Royal Prince Alfred Hospital North West Precinct Redevelopment

PREFERRED PROJECT REPORT

Architectural Design Statement

Document Reference: 3599-0603-011

**NORTH ELEVATION [LUCAS STREET]**

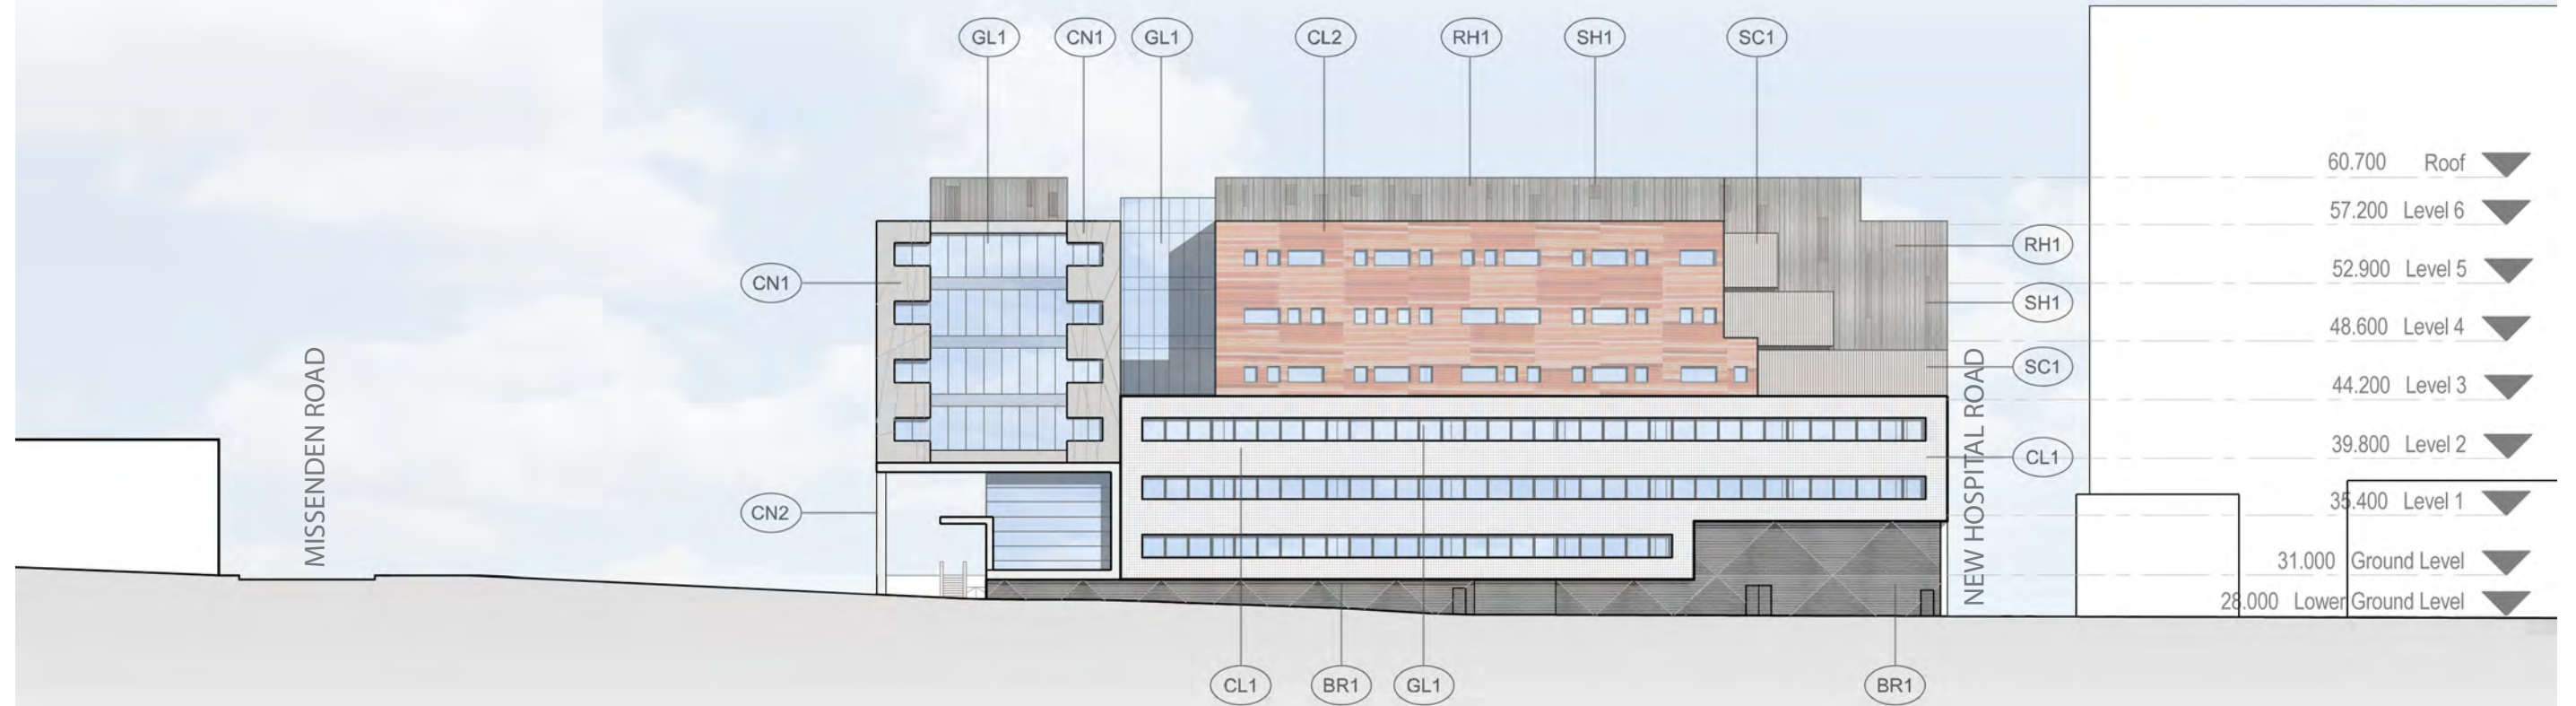
The Ambulatory Care accommodation, predominantly on Ground Level to Level 2, is expressed by terracotta cladding tiles with long horizontal windows to the finished ceiling height. This facade incorporates infill spandrels to window sills to reticulate building services and to ensure flexibility for the necessary location of furniture and equipment. Window mullions are arranged on a modular grid that can anticipate future wall alignments. The openings on first floor level are expressed by vertical fins that assist in modularity and generating depth to the overall elevation.

The Mental Health unit accommodation is provided at Levels 3 to 5 and is expressed by light weight composite panel cladding as the facade material. The cladding is expressed horizontally and openings are located with consideration to the perimeter accommodation, predominantly the mental health inpatient bedrooms. Whilst the opening sizes are relatively consistent, variety is added to this portion of the elevation in providing infill terracotta cladding of various striations within those openings. The west extent incorporates perforated sheet metal cladding to the mental health courtyards that allows filtered sun to penetrate the courtyard spaces.

The light weight composite panel cladding provides high thermal and acoustic performance; achieves a contrast to the terracotta cladding at lower levels and assists to break down the building bulk by changing the material expression.

The office accommodation contained within the east portion of the building on Levels 2-5 incorporates a glass curtain facade and terracotta cladding.
